**From:** Lisa Hughes  
**Sent:** 25 January 2010 09:47  
**To:** Planning  
**Subject:** FW: Law School

2009/1740/MA

**From:** Tom Ashley [REDACTED]  
**Sent:** 22 January 2010 12:48  
**To:** Lisa Hughes  
**Subject:** Law School

Non-Material Amendments

Drawing Title
**FIRST FLOOR PLAN
ROOF PLAN**

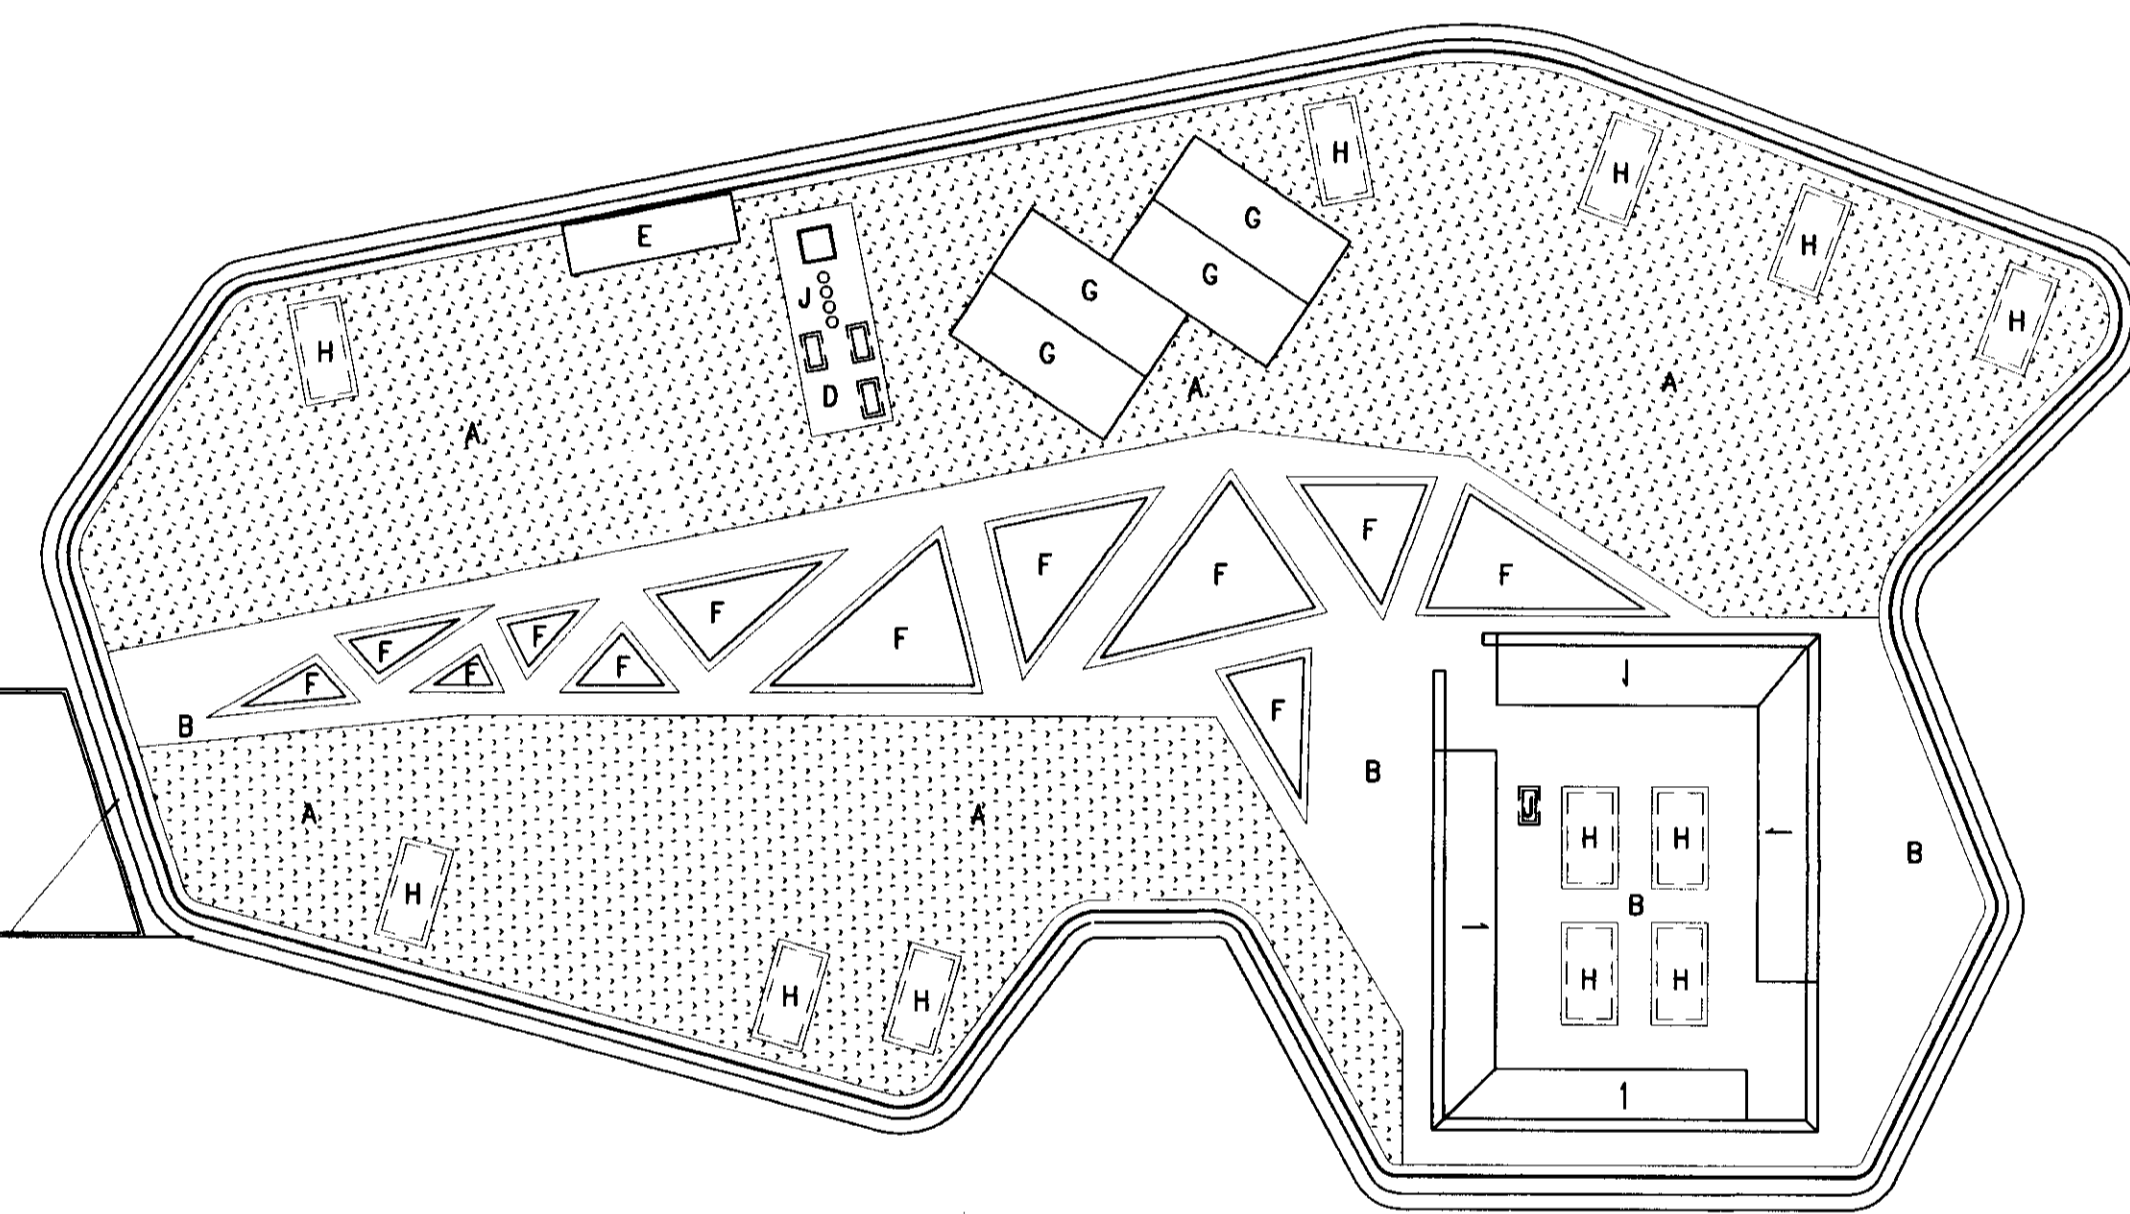
1. Reconfigured WCs and cleaner's store to ground & first floor plan [2228C(PL)100/101]
2. Additional stores to ground floor plan [2228C(PL)100]
3. Switch room to ground floor plan [2228C(PL)100]

4. 'Bridge link' to north external teaching space for level egress [2228C(PL)100]
5. Patch room moved from ground to first floor [2228C(PL)100/101]
6. Dedicated roof access stair (previously no fixed means of access) [2228C(PL)101]

7. Enlarged & relocated roof access hatch [2228C(PL)101]
8. Triangular rooflight/estack cowls omitted above teaching rooms- now simplified ventilation cowl [2228C(PL)101]

9. Glazed rooflights above atrium space rationalised (height/no. reduced) [2228C(PL)101/300/301/400/401]
10. PV cells to roof [2228C(PL)101/400/401]
11. Court lantern: glazing omitted (now dark rainscreen cladding). Form rationalised. Parapet height reduced (-200mm) [2228C(PL)300/301/400/401]
